# PONDEROSA AT LORSON RANCH FILING 3

## A PLANNED UNIT DEVELOPMENT AND PRELIMINARY PLAN

REV #	REVISIONS	DATE
1	1st Response to County Comments	1.8.2020
2		
3		
4		
5		
6

LOT DETAILS

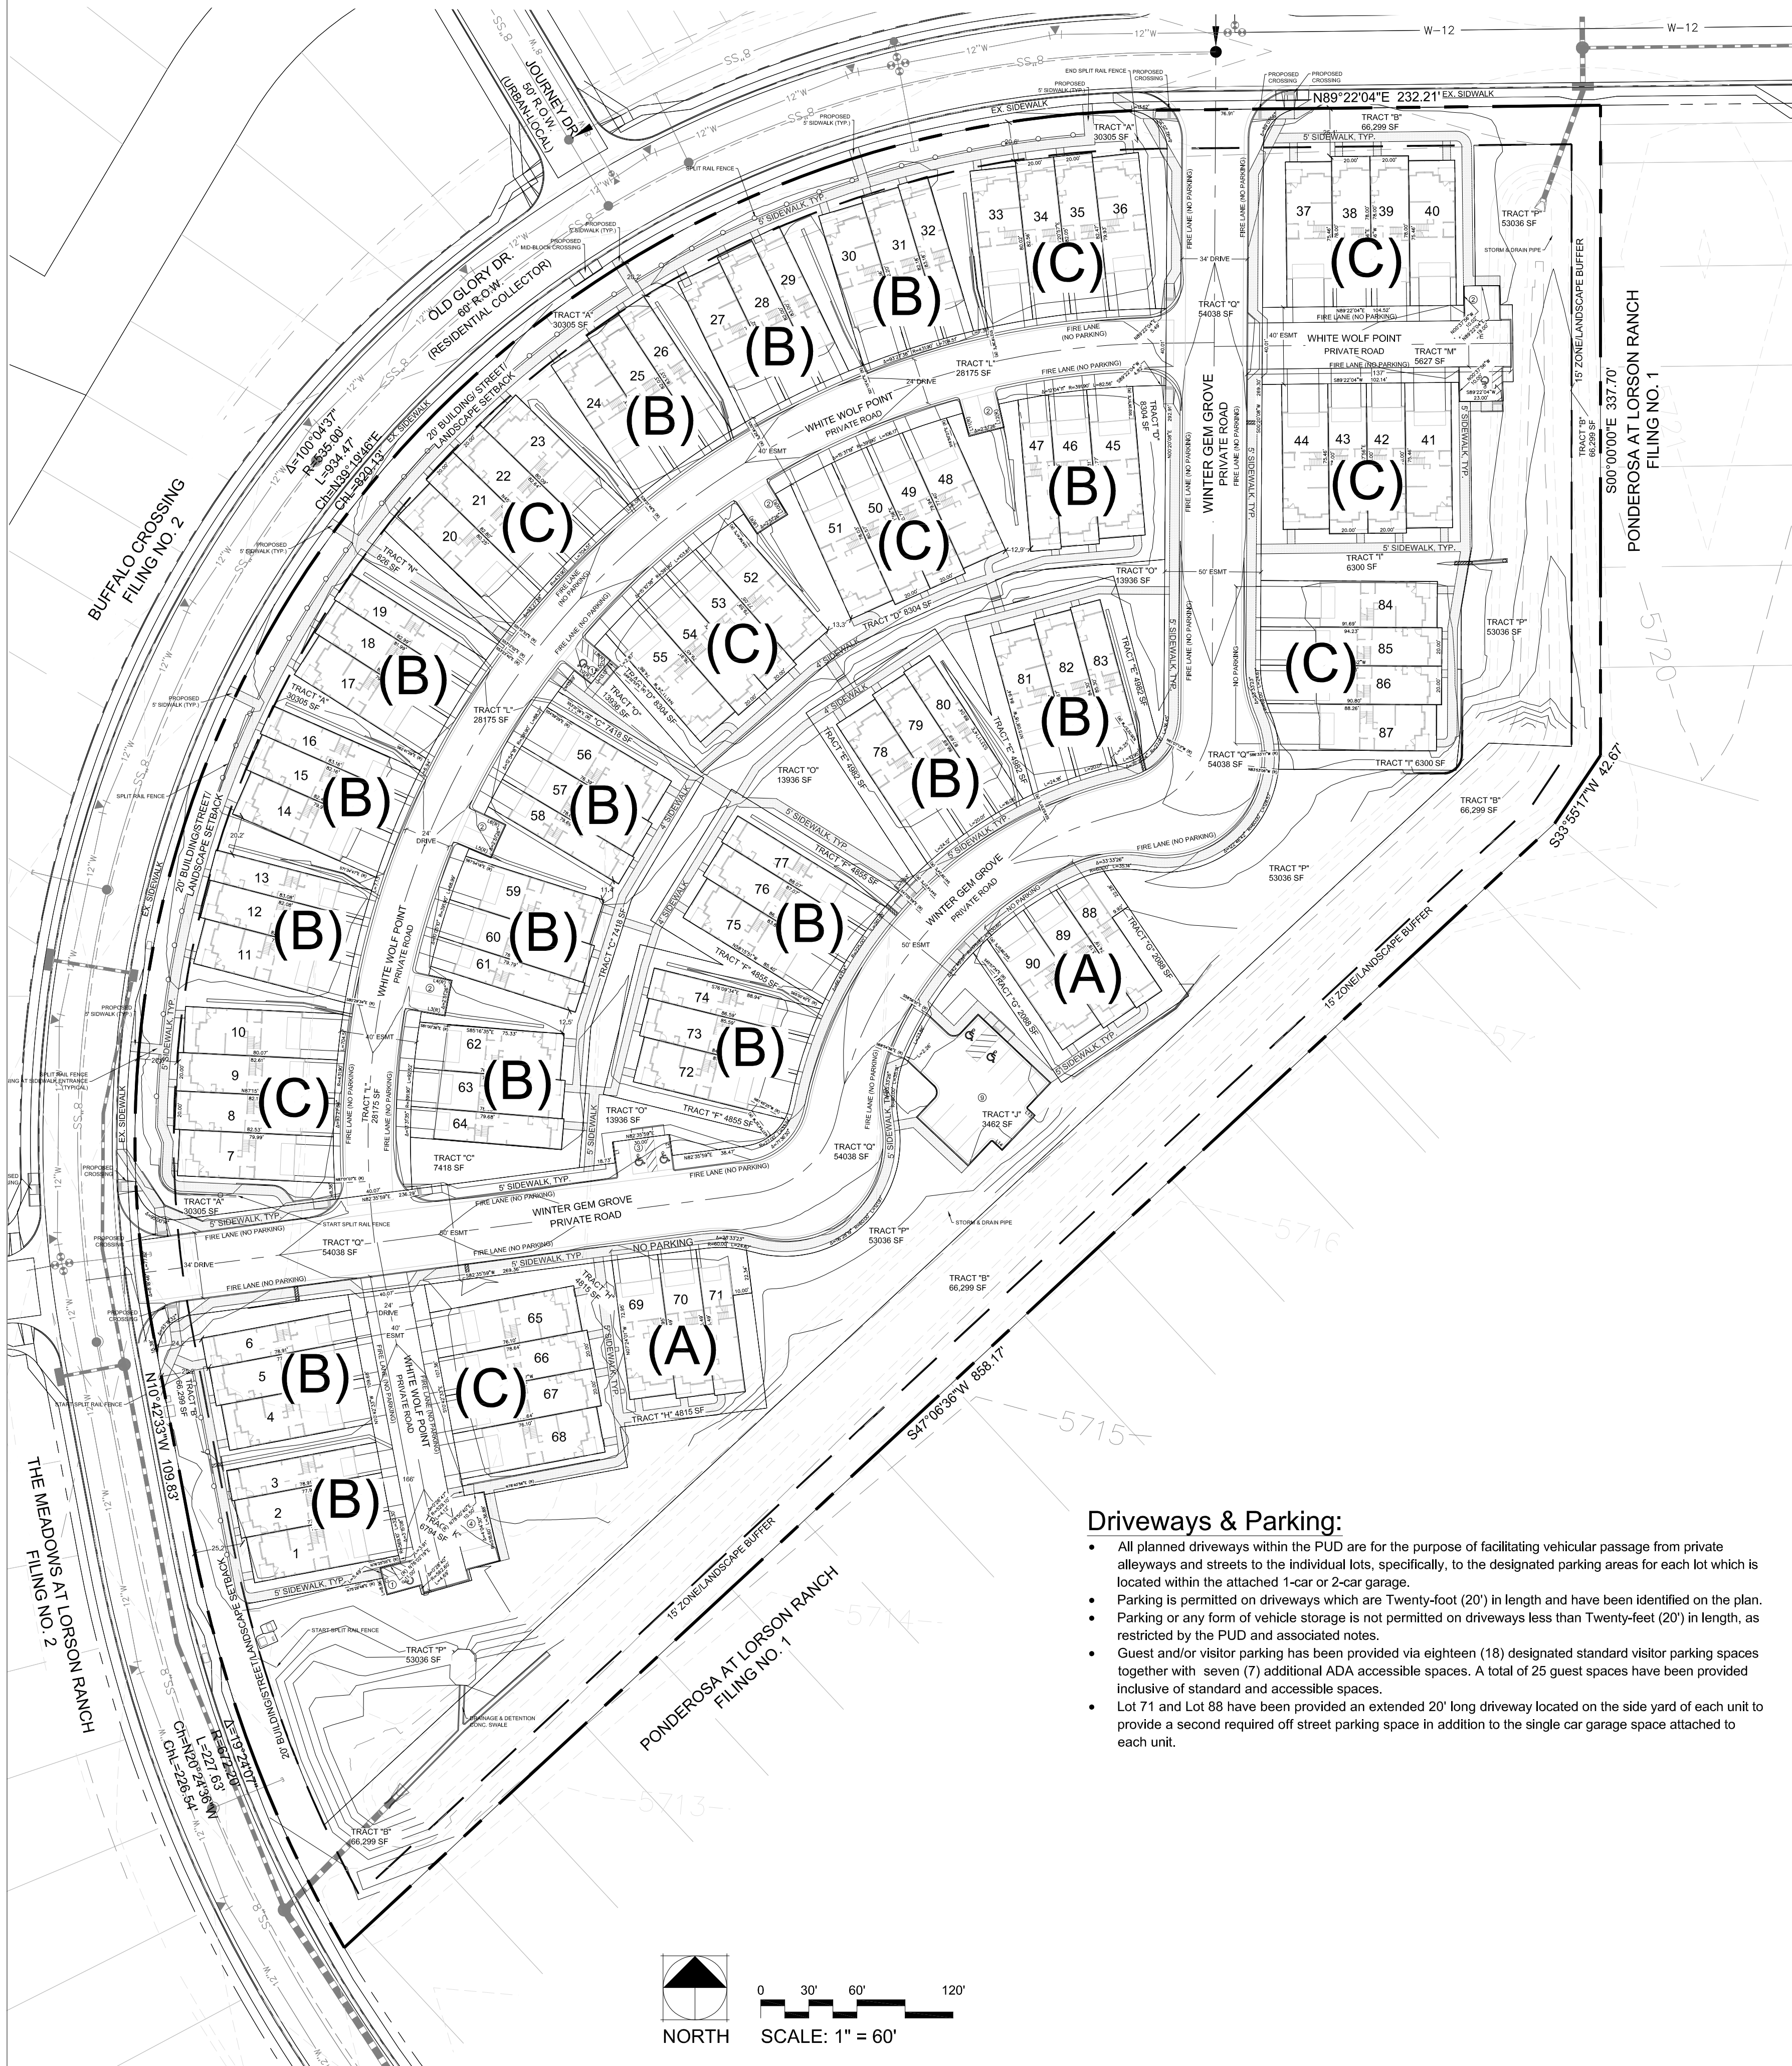
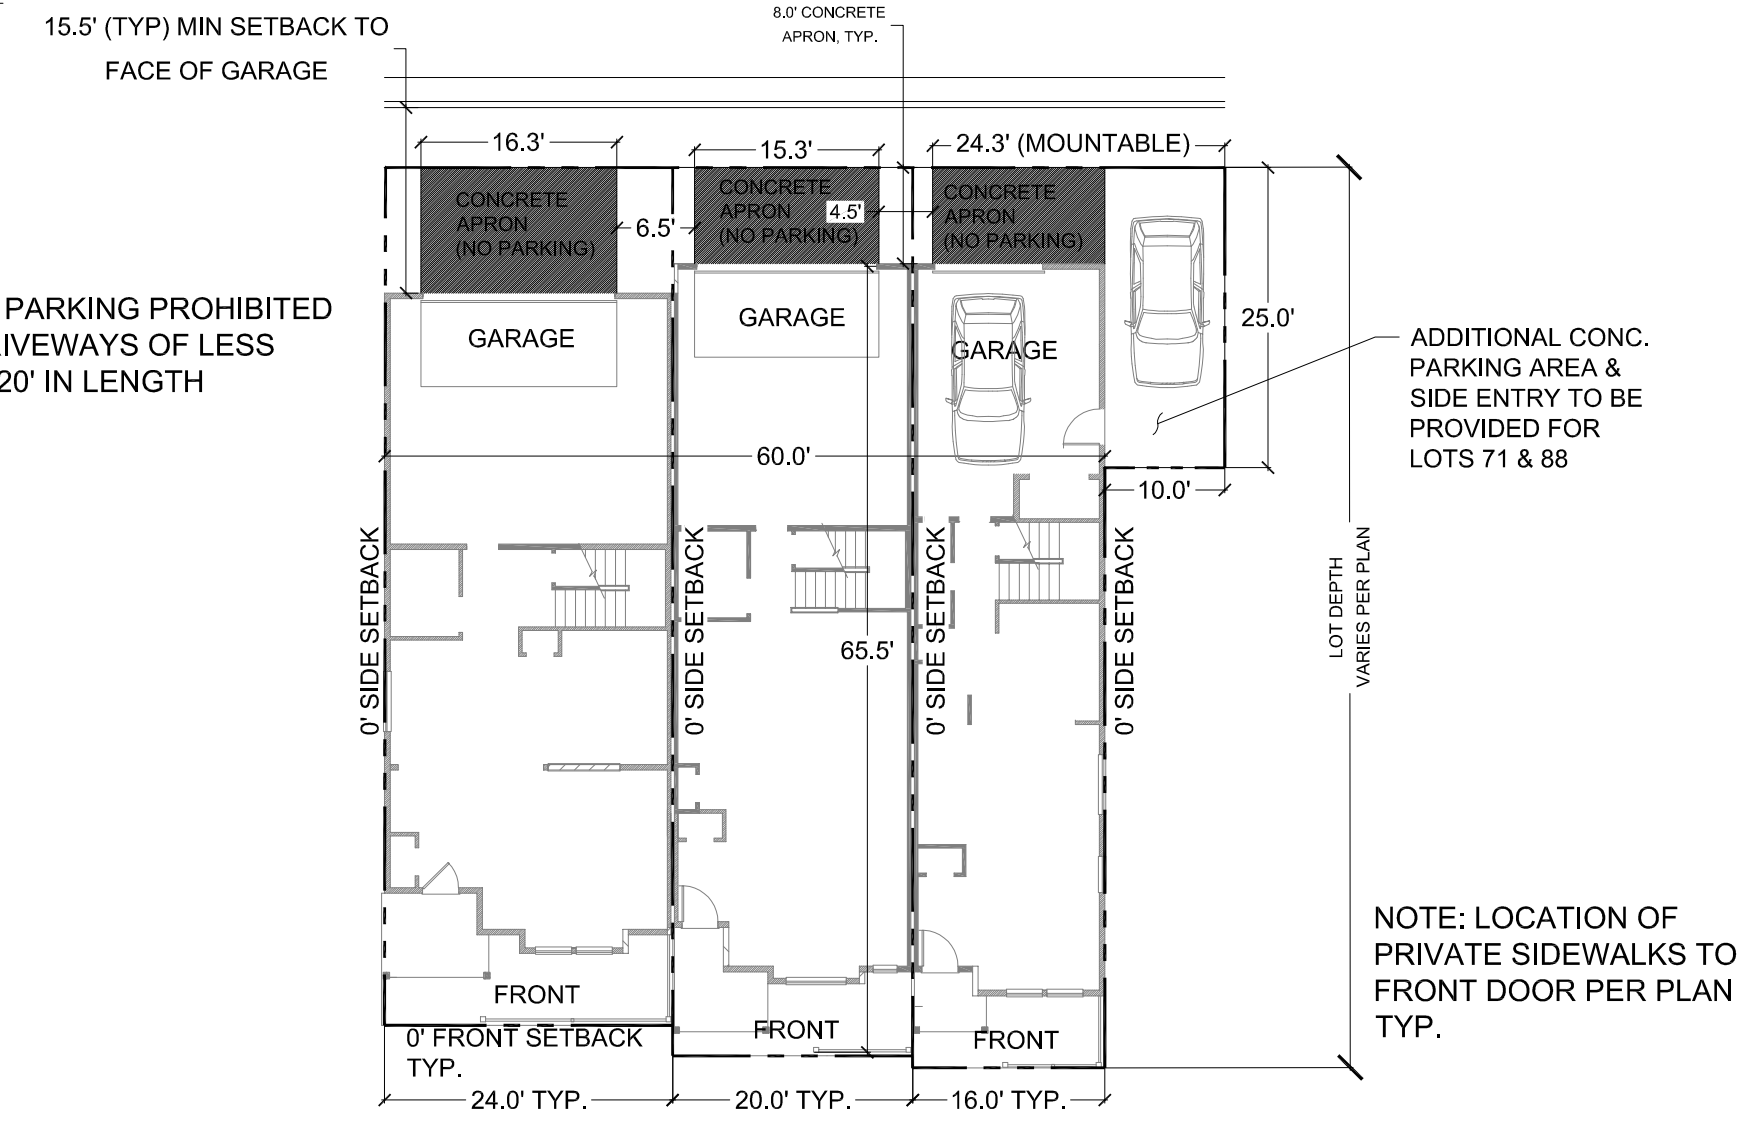
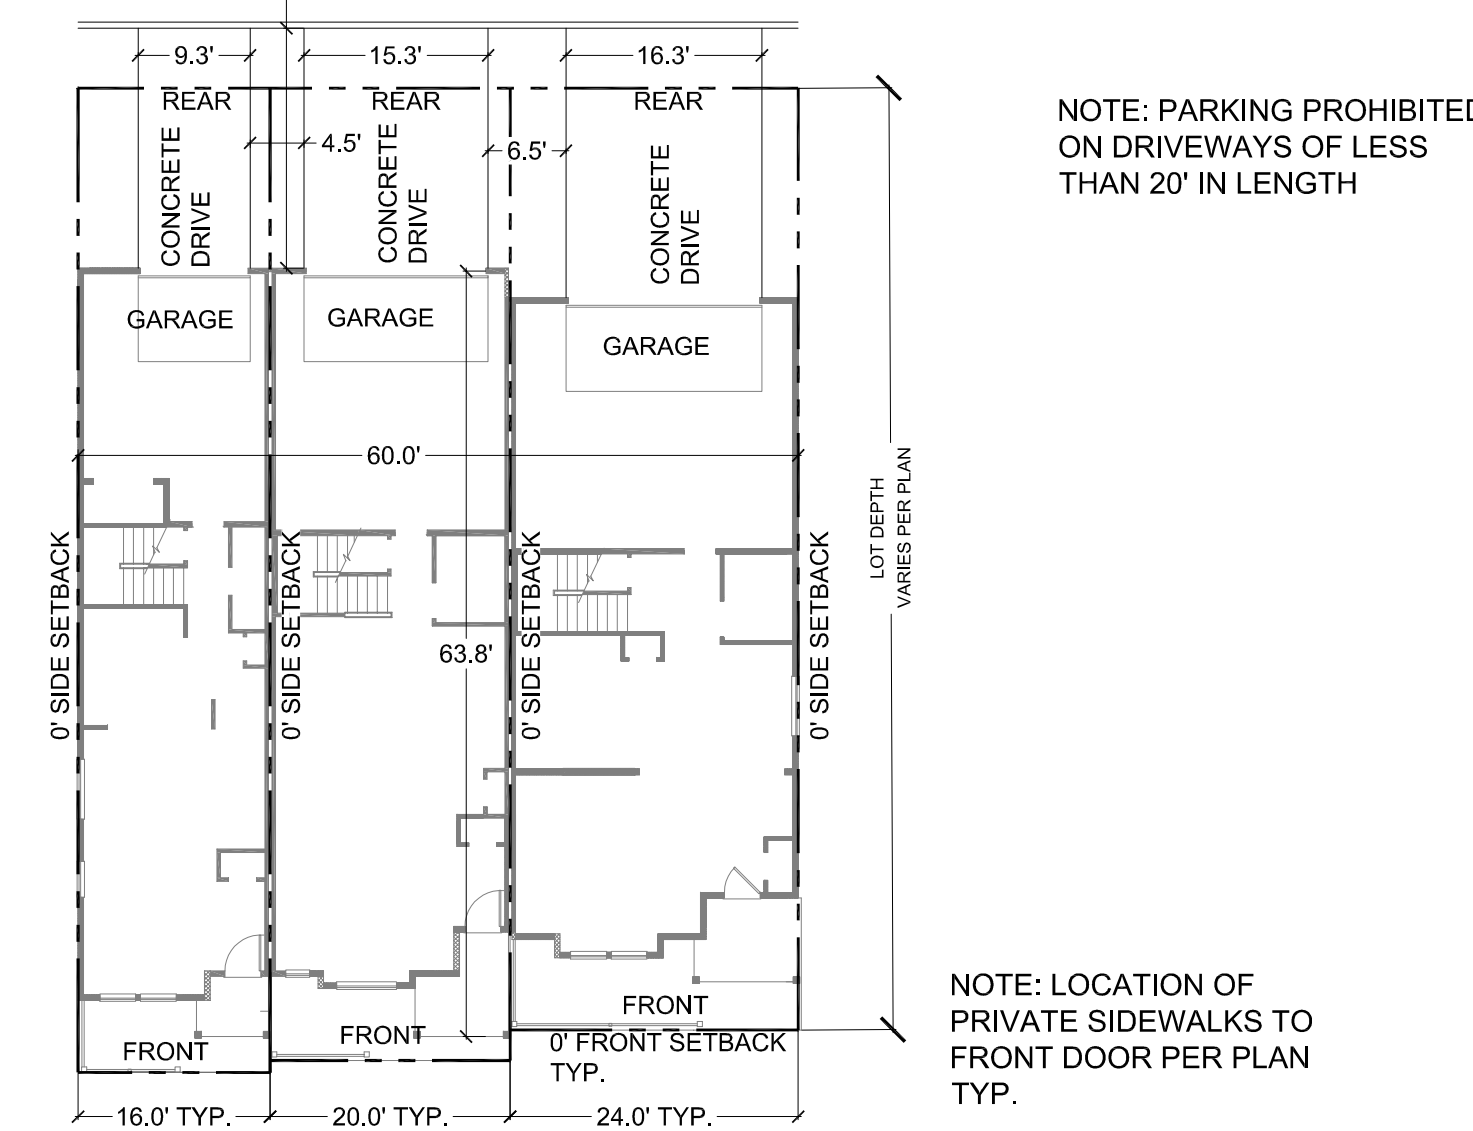
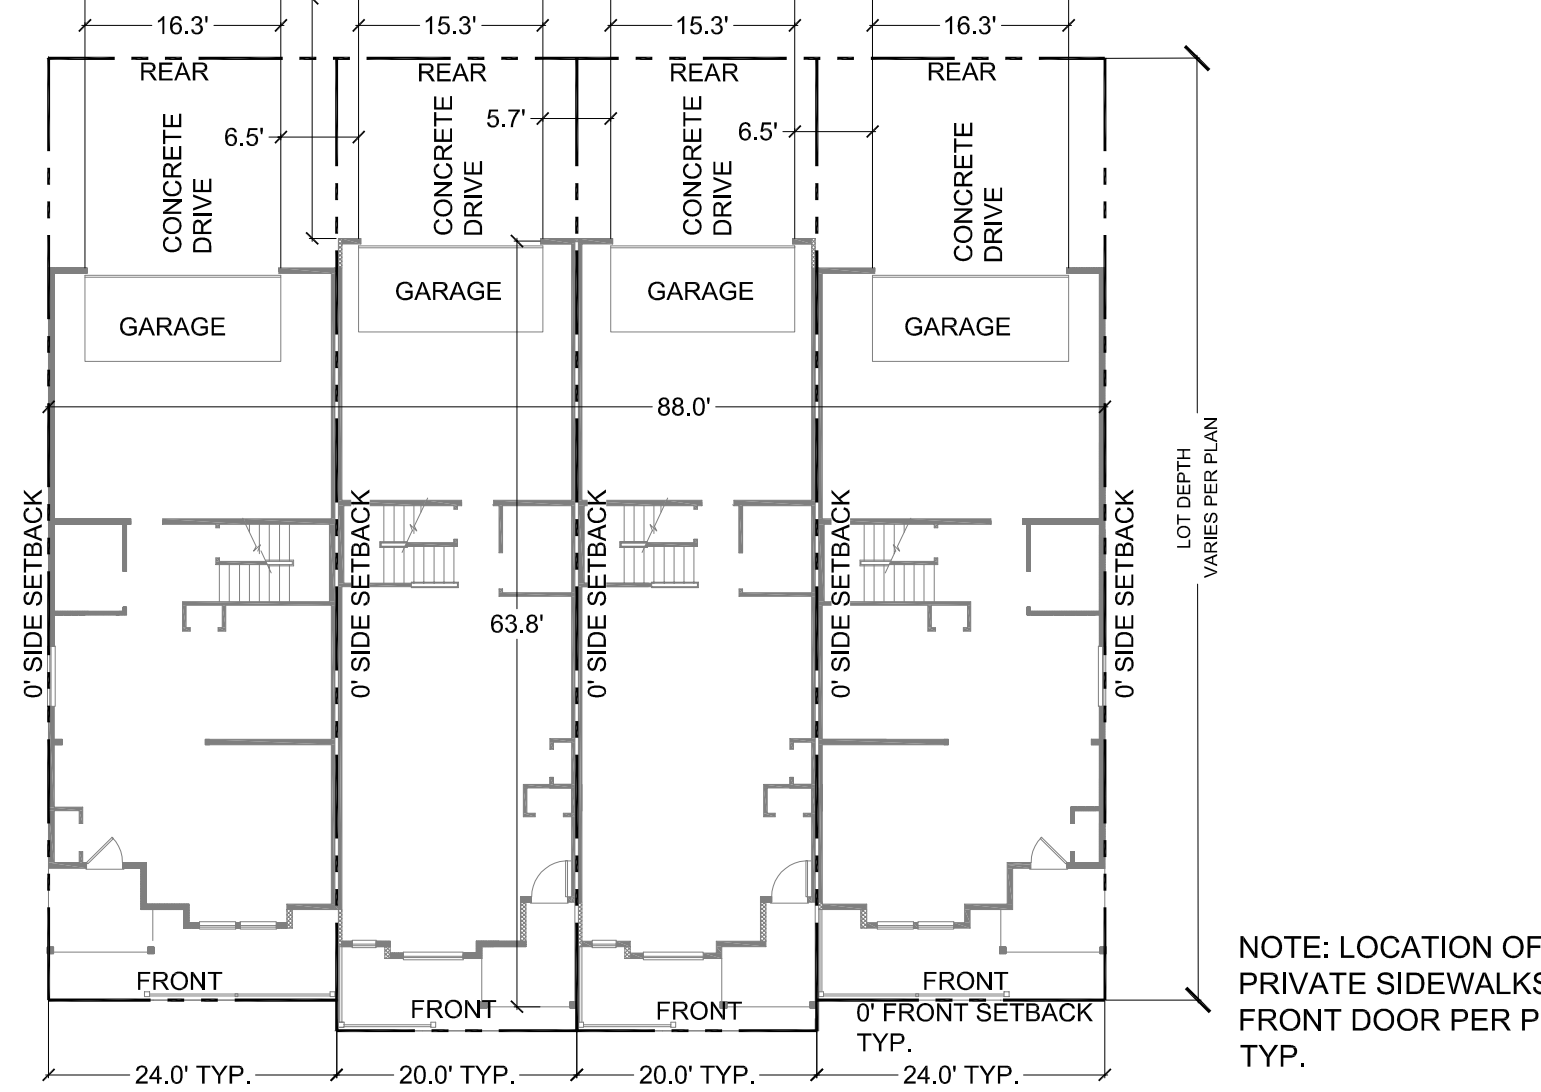
WHERE ARE THE LOT LINES AND DIMENSIONS OF LOTS, SF OF LOTS, DISTANCES AND ANGLES BEARINGS OF ROADS PERIMETER ETC... THIS IS THE LOT DETAIL SHEET.... THIS IS A PRELIM PLAN WHICH SHOULD CLEARLY DEPICT THE LOT LINES, EASMENTS ETC...

follow the prelim plan checklist and verify all items are on it. Ask Jeff Rice if you need help for eng related checklist items...
